Letter No. **A1/33922/2004**

Sub: **CMDA - Planning Permission - Construction of Ground Floor + First Floor (part) Residential building at Plot No.72, Parvathy Avenue, Ganesh Avenue, 4th Street, Sakthi Nagar, Porur, Chennai 116 in S.No.59 pt. and 60 pt. of Porur village - Development charges and other charges to be remitted - Reg.**

PLAN SHOWING THE PROPOSED NEW CMDA 'A' CHANNEL
 C.No. PA/33922/2004
 4TH STREET, SHAKTHI NAGAR,
 CHENNAI / - 600 116
 P. A. I. 21/04/10

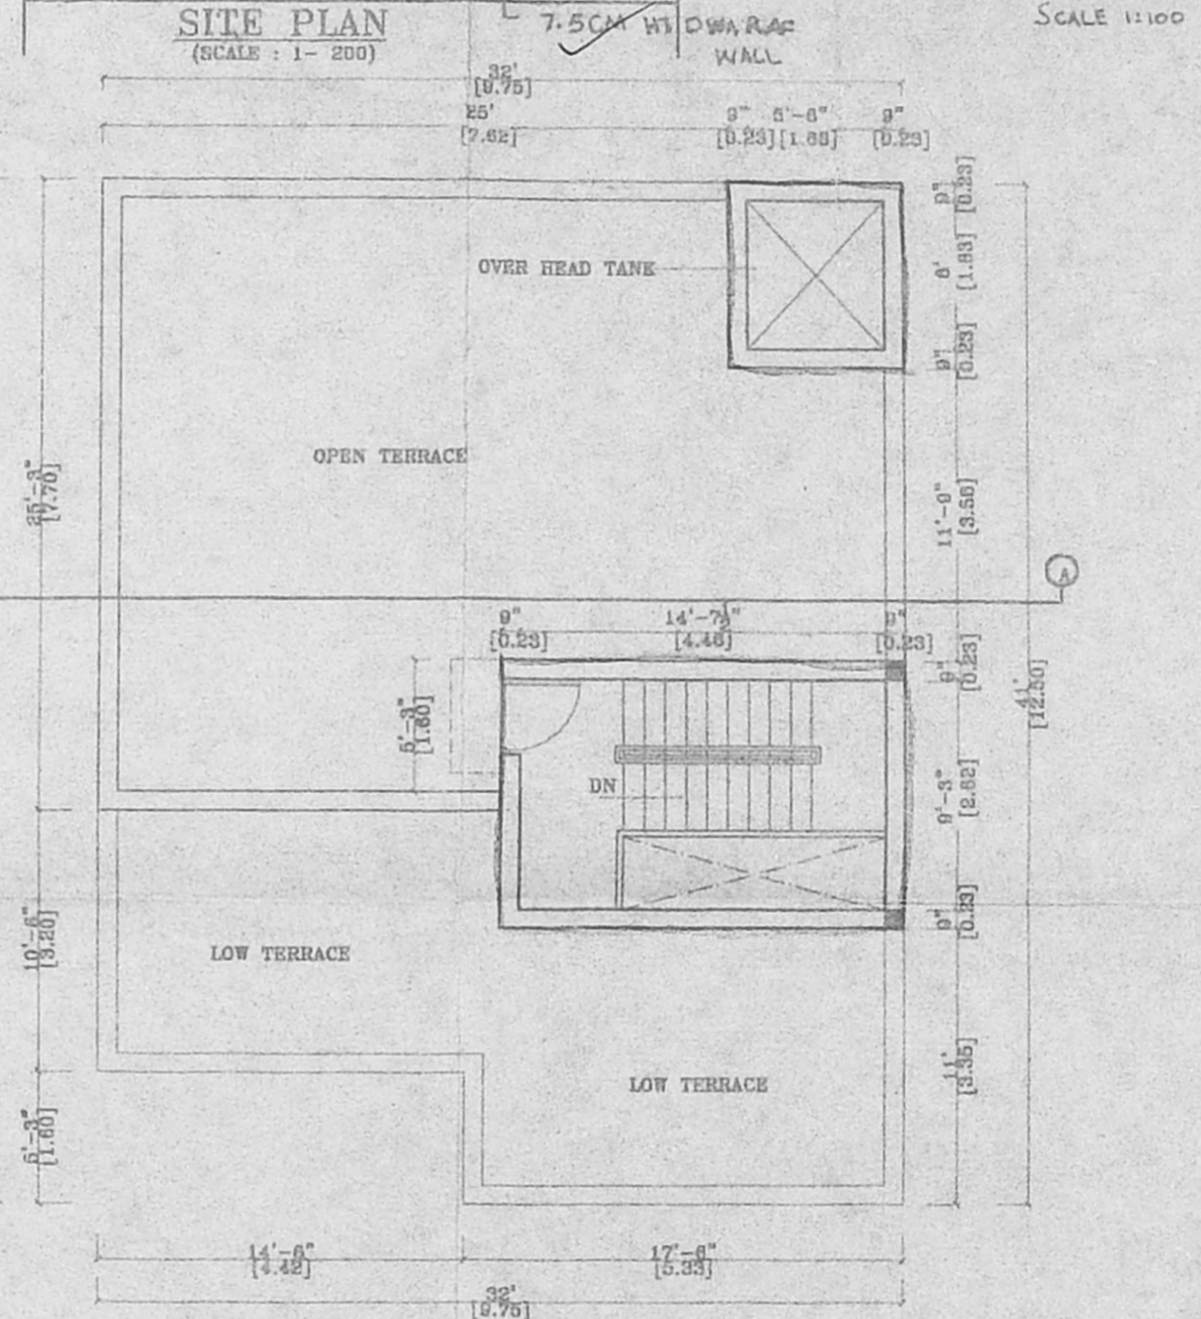
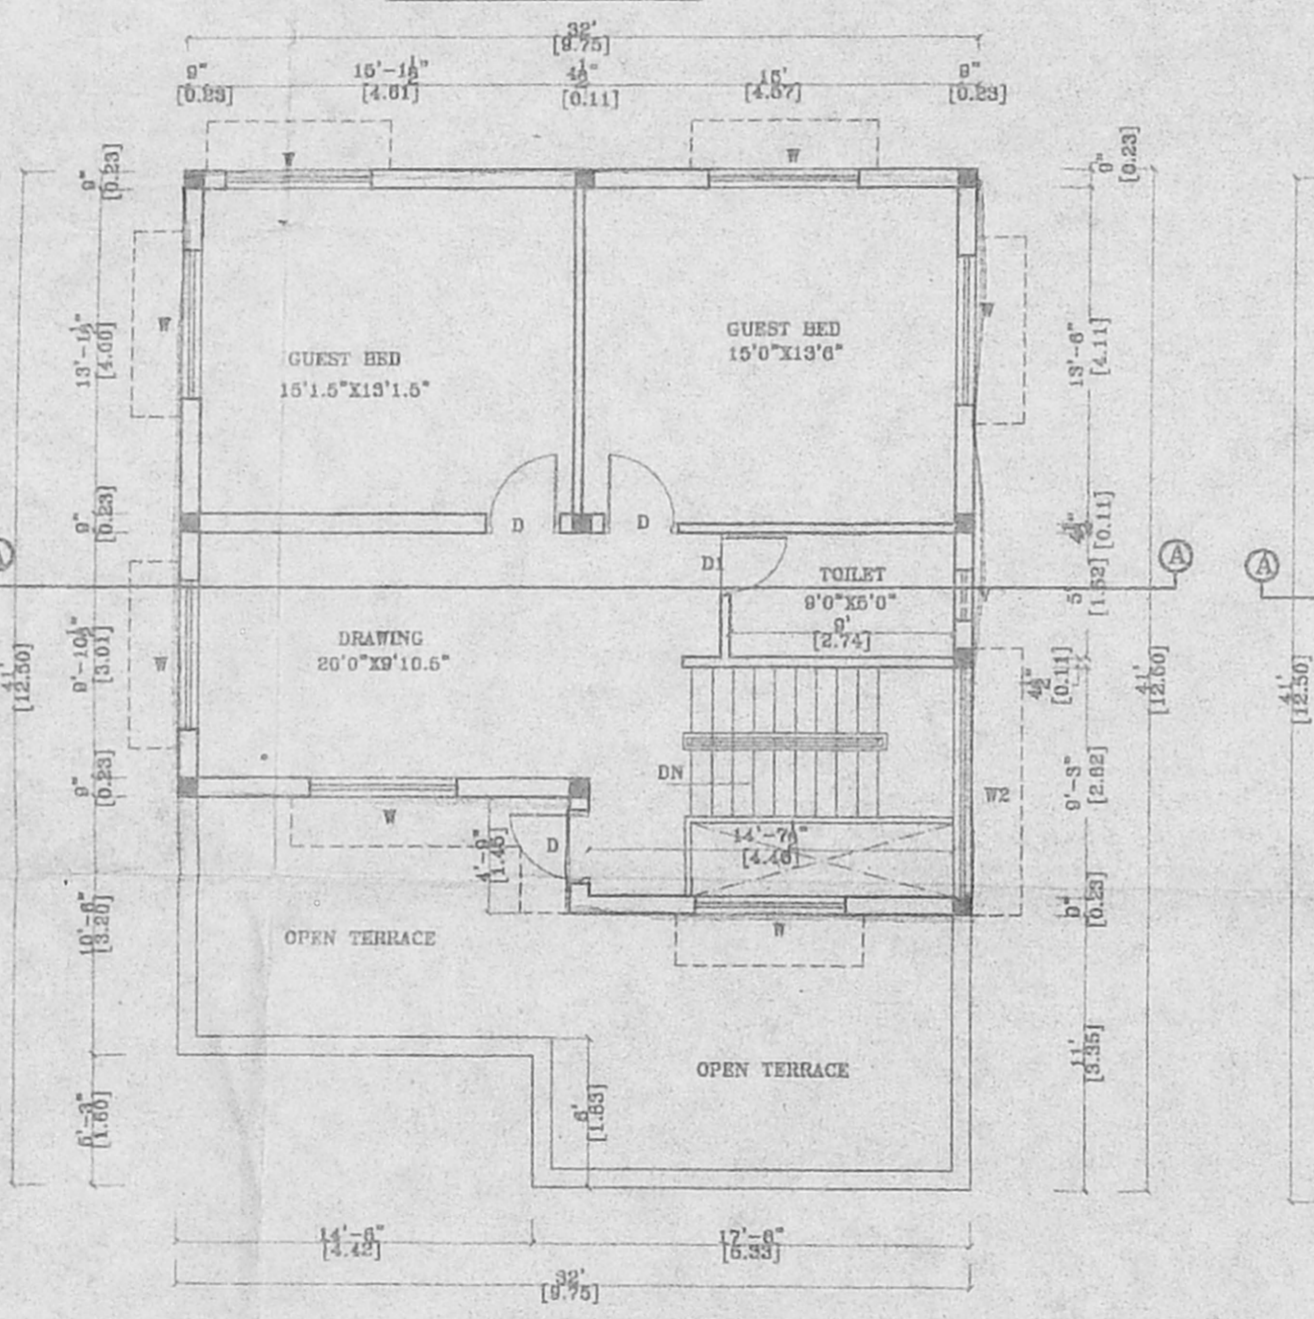
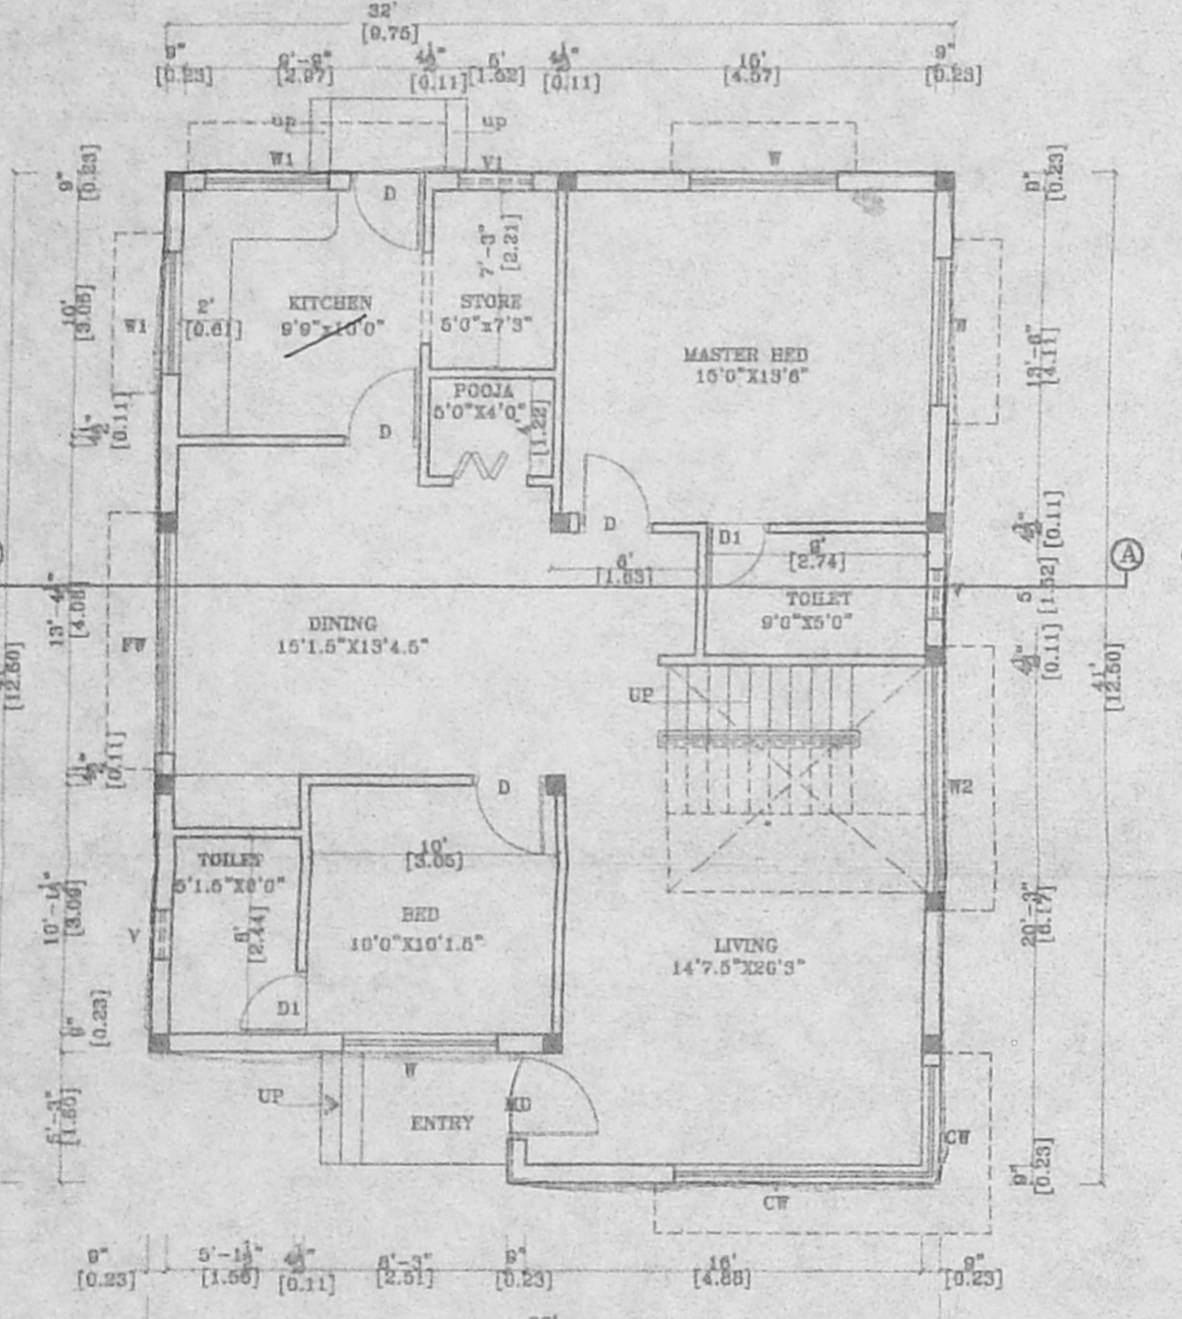
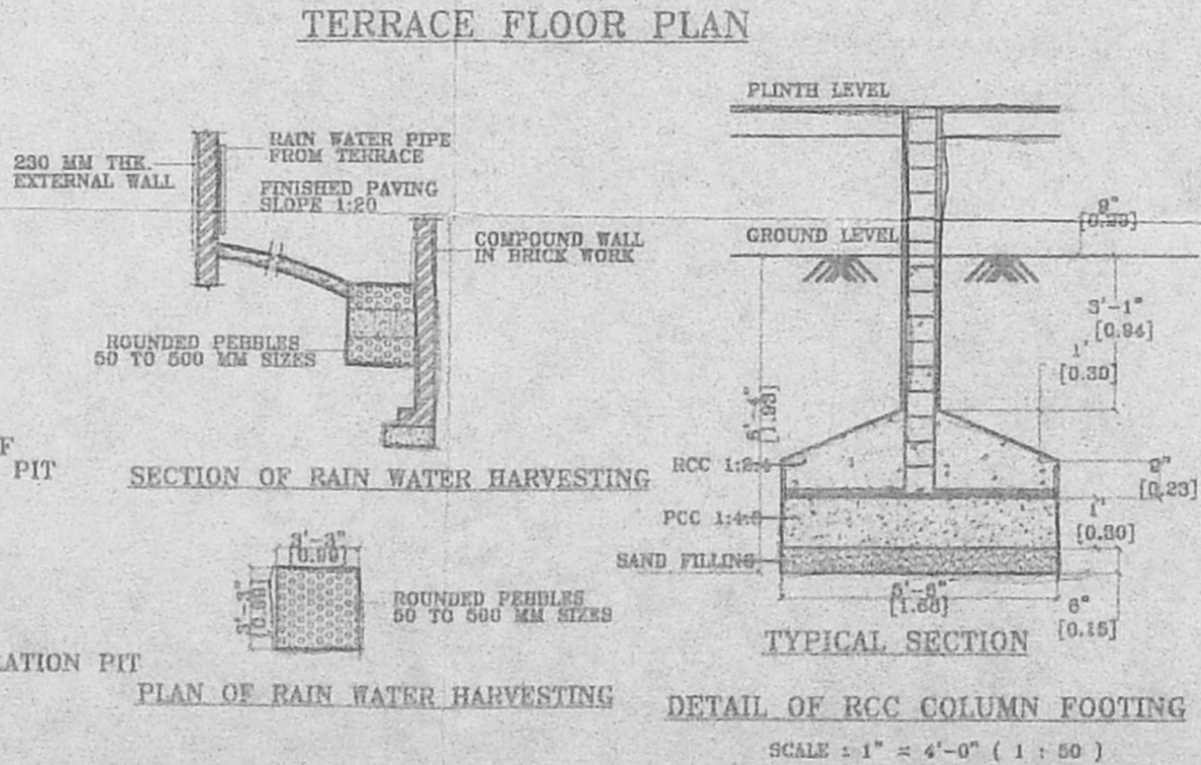
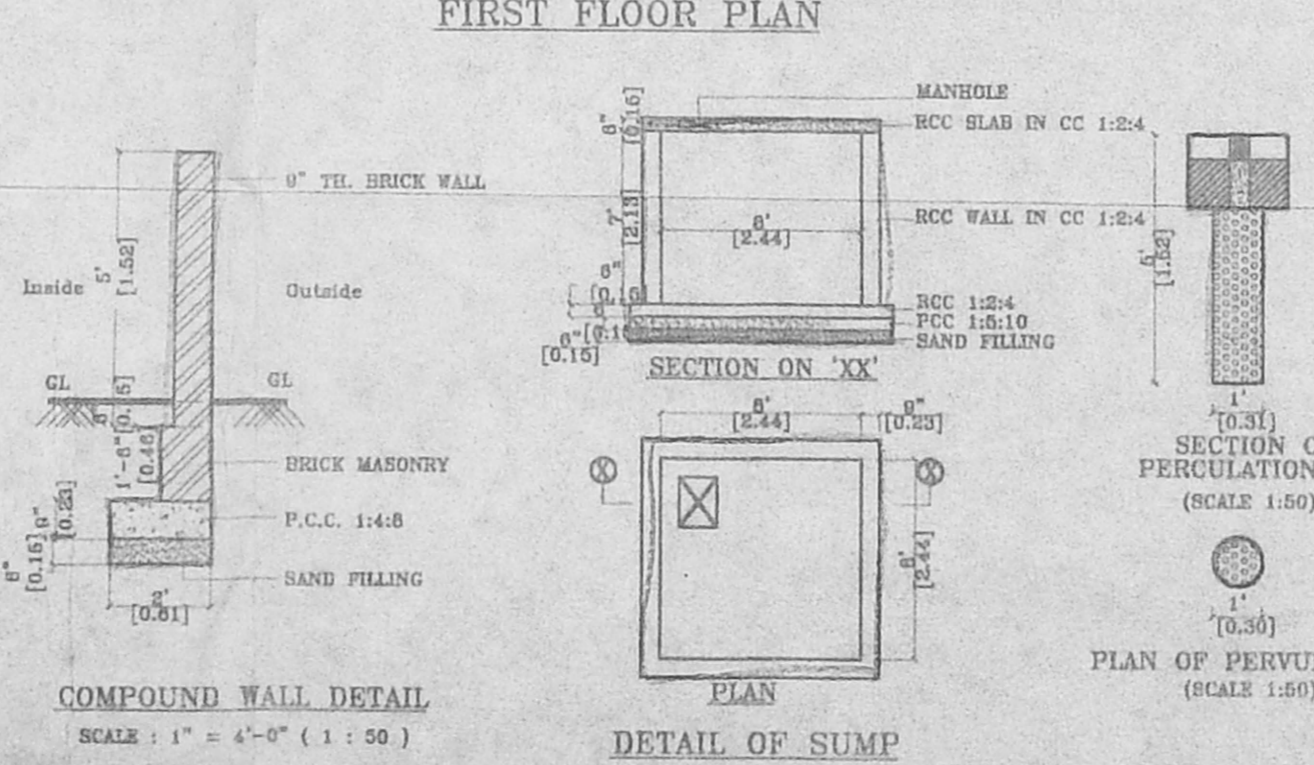
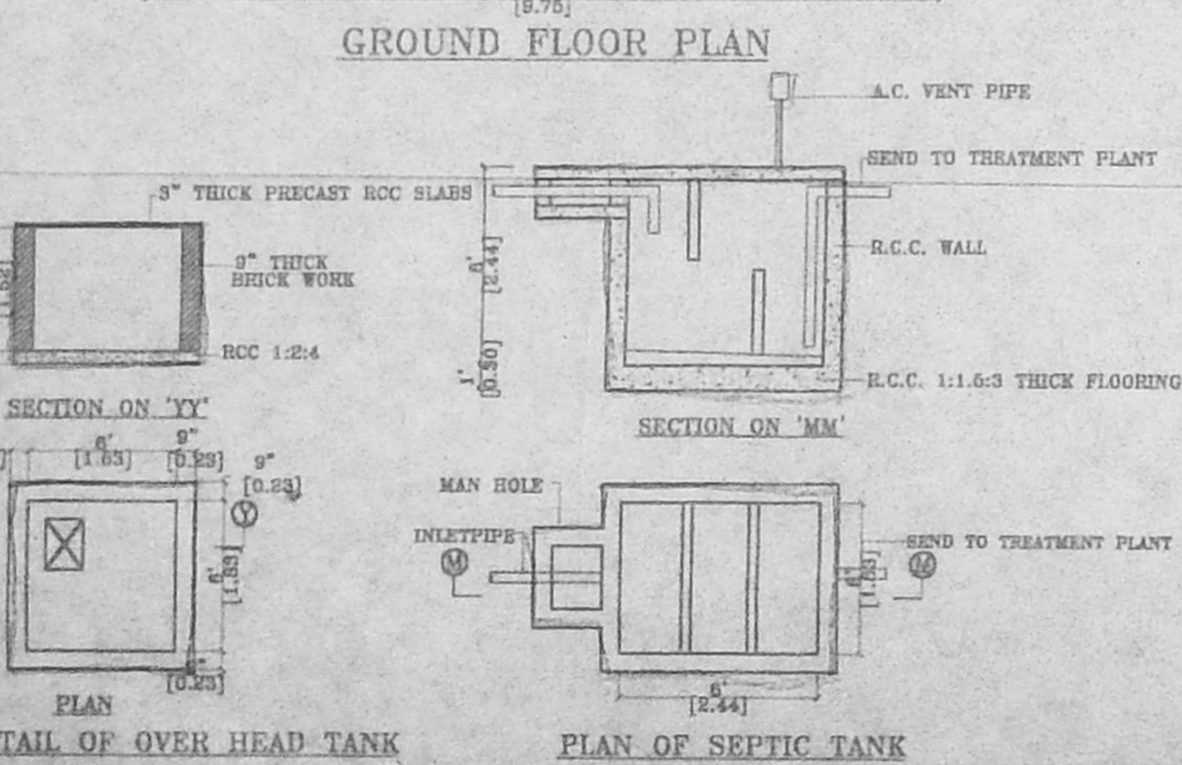
b. **Five copies of revised plan showing the following particulars to be submitted:**

1. **Clear set back available at curcial point to be mentioned.**

2. **Elevation details of compound wall with 7.5 cm dwarf wall along the gate to be shown.**
